Recommendation Report for Planning Permission for Works or Extension to a Dwelling

REF NO: M/86/19/HH

LOCATION: 44 Sea Way
Middleton-On-Sea
PO22 7SA

PROPOSAL: First floor rear extension

Revisions			
44 SEA WAY, MIDDLETON ON SEA, PO22 7SA			
ROOF PLAN PROPOSED			
Scale	1:100 @ A3	Drawn	HS
Date	27/09/2019		
			055/ 025 A

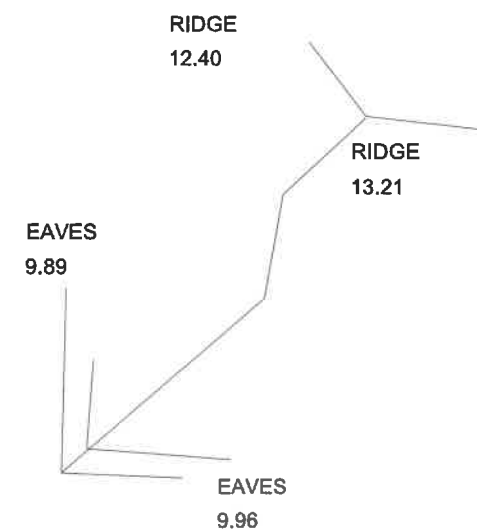
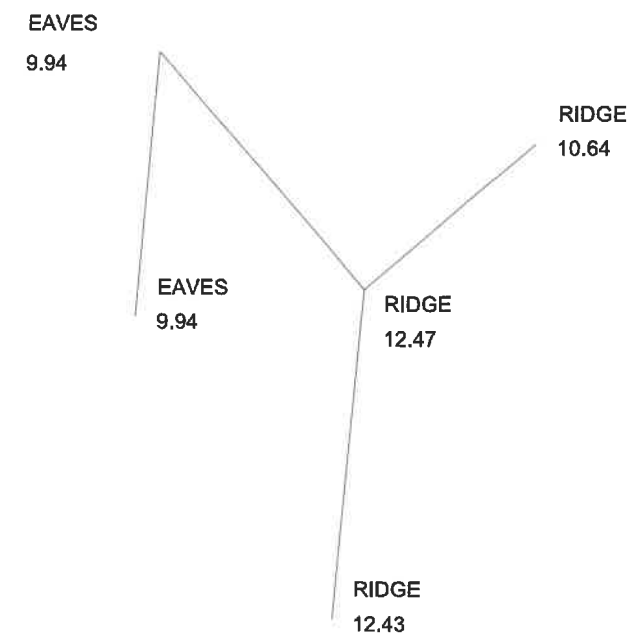
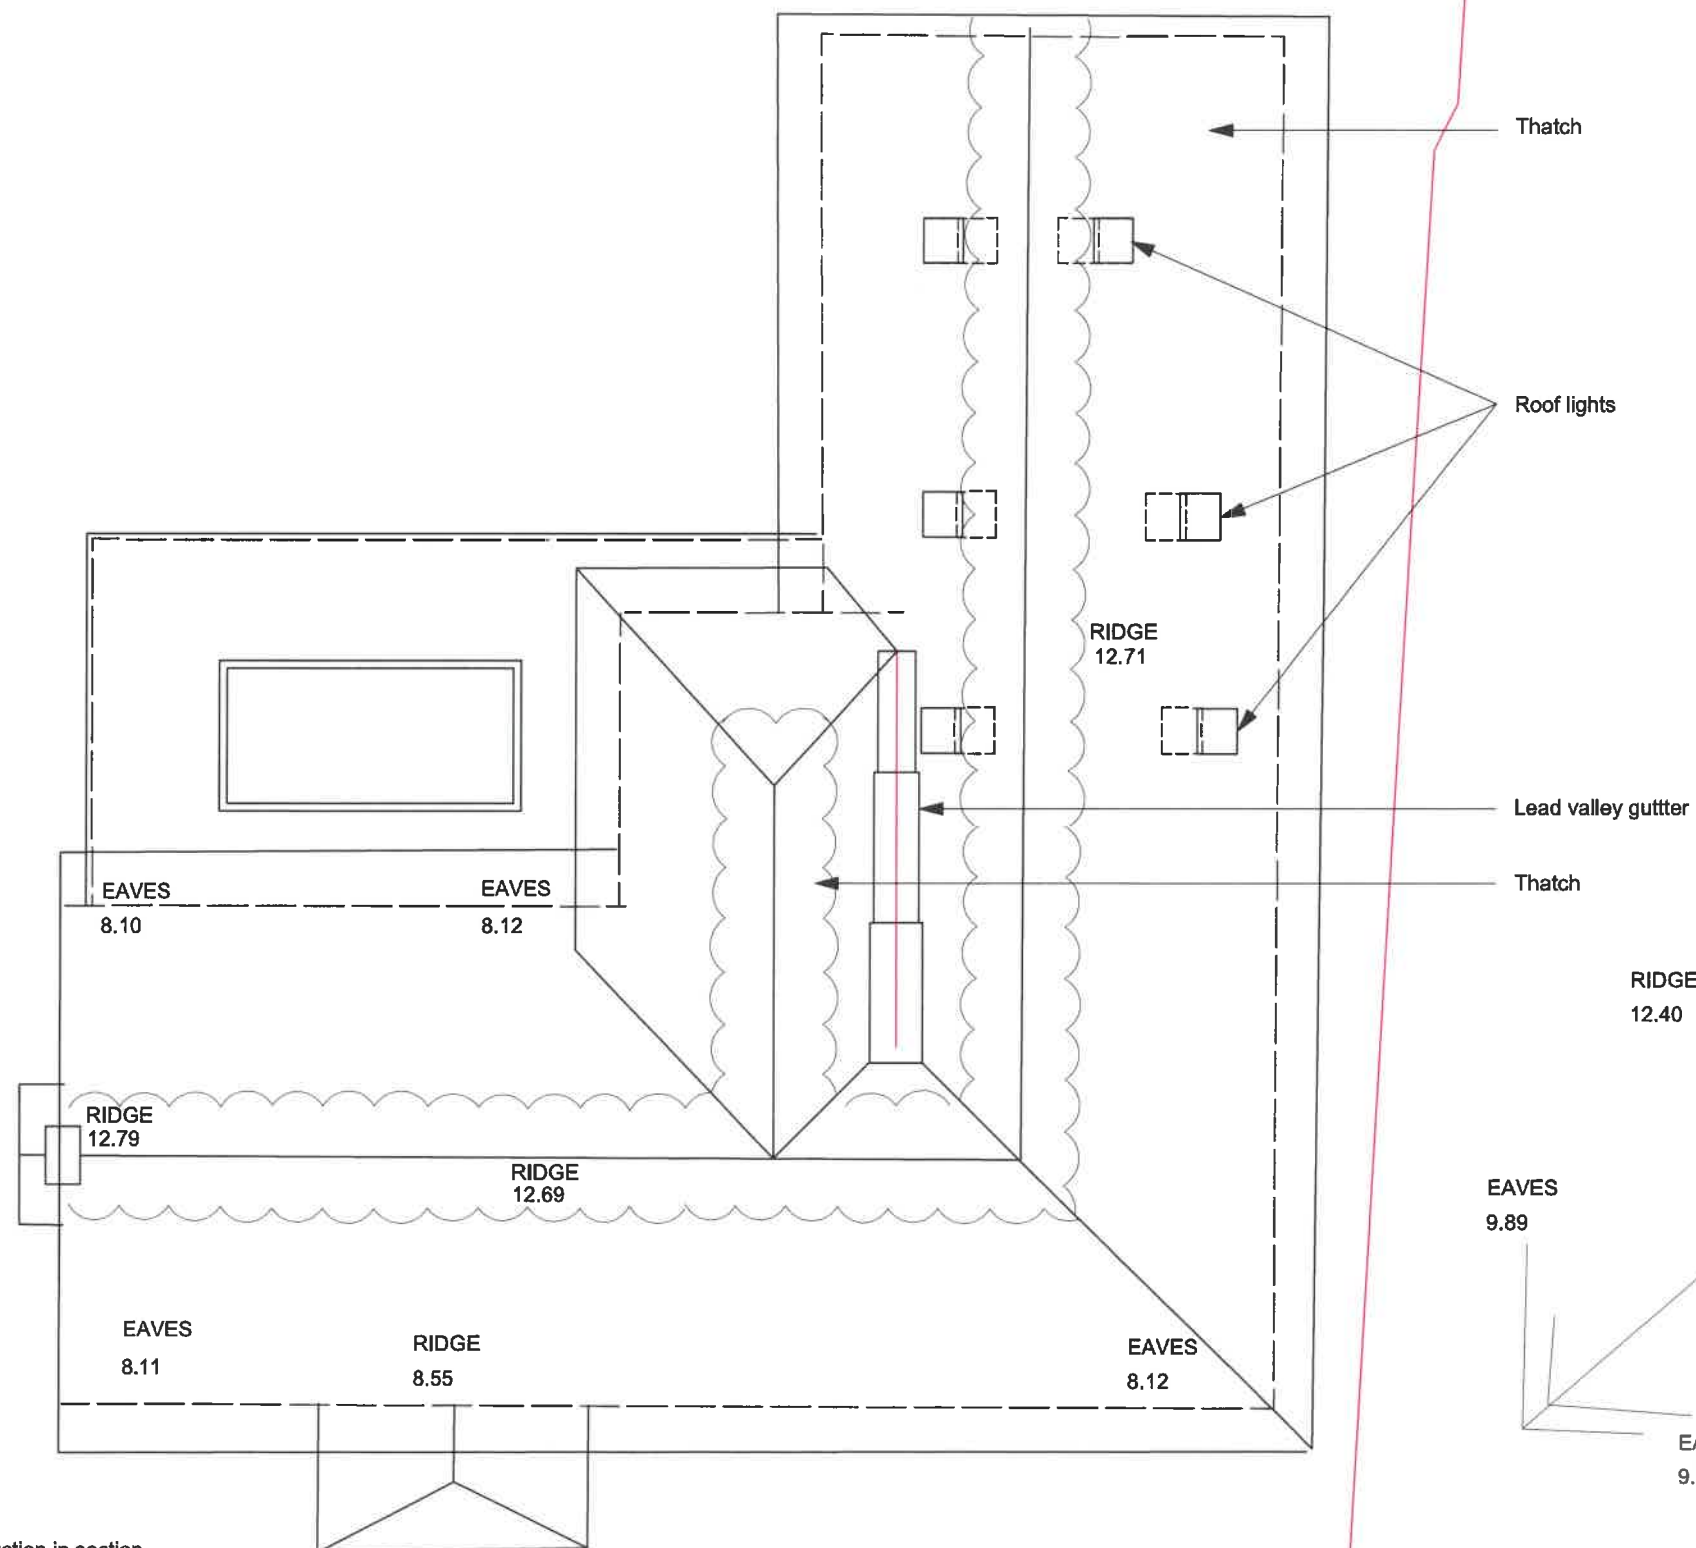
The proposed extension features windows, although the majority of the windows proposed are not considered to result in any views that are not available from the application site at current. There are roof lights proposed on the Eastern elevation of the proposal, these will be conditioned so that they do not provide unacceptable overlooking.
